File No: NTH15/00009
Your Ref: MP10_0160

MP 10_0160 Modification 4: White Rock Wind Farm Project - Alternative Transmission Line and Connections

Figure 7-4 – White Rock Wind farm and alternative grid connection facility access routes

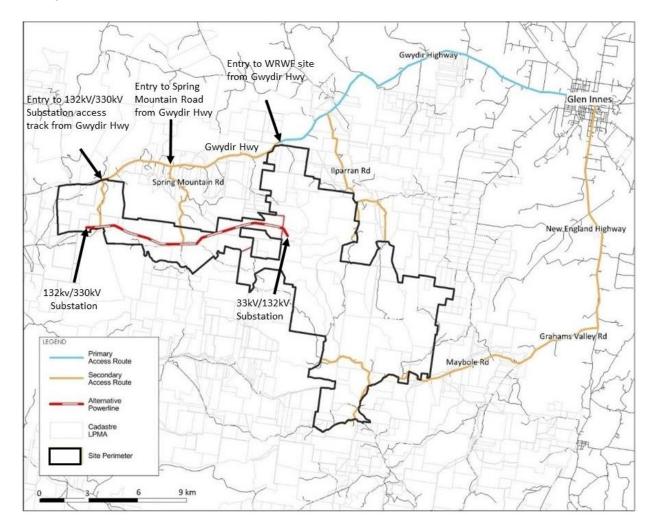
Roads and Maritime has reviewed the information provided and requires the developer to prepare a Traffic Impact Assessment (TIA) to identify likely traffic impacts of the proposal and determine any road infrastructure upgrades required to mitigate these impacts.

- The total impact of existing and proposed development on the road network with consideration for a 10 year horizon.
- The volume and distribution of traffic generated by the proposed development during construction and operation.
- Sight distance measurements at proposed access locations and affected intersections.

- Details of existing and proposed access treatments including concept designs for any works proposed on the classified (State) road network (Gwydir Highway).
- Details of proposed improvements to any affected intersections, including concept designs for any proposed improvements to the classified (State) road network.
- Details of improvements required to accommodate an increase in right turning movements from the Gwydir Highway into the existing (eastern) access for White Rock Wind Farm (WRWF).
- Details of servicing and parking arrangements.
- Impact on public transport (public and school bus routes).
- Connectivity for active transport modes such as walking and cycling.

It is recommended that the developer seek in-principle agreement from Roads and Maritime to the concept designs for all works deemed necessary on the classified (State) road network (Gwydir Highway). This should be sought prior to approval of the modification to enable the works to be included in the conditions of approval.
